**KIRKLEES METROPOLITAN COUNCIL  
INVESTMENT & REGENERATION SERVICE**

**DELEGATED DECISION FOR DISCHARGE OF CONDITION A.4 -  
NOTIFICATION OF A PROPOSED ENLARGEMENT TO DWELLINGHOUSE**

<b>Reference no.</b>	<b>2025/HH/91685/E</b>
<b>Site Address</b>	<b>24, Torridon Road, Dewsbury, WF12 7NX</b>
<b>Description</b>	<b>The proposal is for erection of single storey rear extension. The extension projects 6m beyond the rear wall of the original dwellinghouse. The maximum height of the extension is 4m, the height of the eaves of the extension is 3m</b>
<b>Recommending Officer</b>	<b>Molly Storer</b>

**DECISION - REFUSED**

PROPOSED SITE PLAN

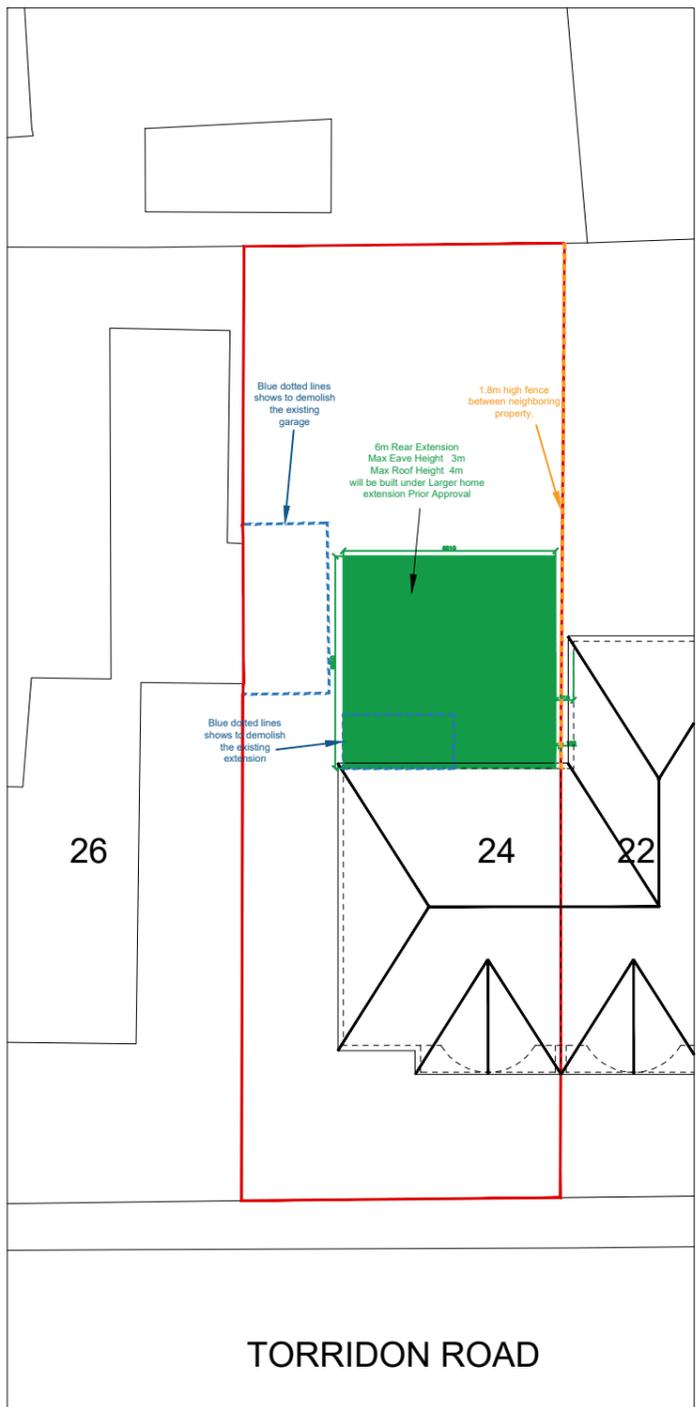
Aerial imagery from 2021 shows two elements to the rear of the property one being a garage which is proposed to be demolished as part of the development. This element is not considered to be an original part of the dwellinghouse as was added later than 1965. However, the other element is considered to be an original part of the dwelling house which has a 1.45m projection from the rear elevation. The proposed extension projects from the rear of the original dwellinghouse by 6 metres along part of the rear elevation and 4.55 metres beyond an existing part rearward projection which is

proposed to be demolished. The Council's historical imagery dated 1933 does not show the dwellinghouse to have been built. However, imagery dated 1955, 1956, 1968 & 1968 consistently indicate the existing rearward projection was original to the dwellinghouse.

To further support this evidence is that the adjoined property to the application site, No.22, also has a mirrored rearward projection indicating No.22 and No.24 were both constructed as a matching pair of semi-detached properties. This is also a pattern seen along this part and side of Torridon Road with Nos 28 and 26 also having this layout.

Having regard to the Government's householder guide to permitted development rights (2019) and sub-paragraph A.1(j), Class A, Part 1 of Schedule 2 of the Town and Country Planning (General Permitted Development) (England) Order 2015 (as amended) development is not permitted under Class A where the proposed extension extends beyond a side elevation of the original dwellinghouse and has a width greater than half the width of the original dwellinghouse. In this case the submitted plans indicate the proposed extension extends along the whole rear elevation of the property and is therefore contrary to paragraph (j) of Class A and as such cannot benefit from a permitted development.

The proposed enlargement does not benefit from a general planning permission under Article 3(1) and Class A, Part 1 of Schedule 2 of the Town and Country Planning (General Permitted Development) (England) Order 2015 as the rear projection extends beyond a wall forming a side wall of the original dwellinghouse and has a width greater than half the width of the original dwellinghouse contrary to sub-paragraph A.1(j) of Class A.
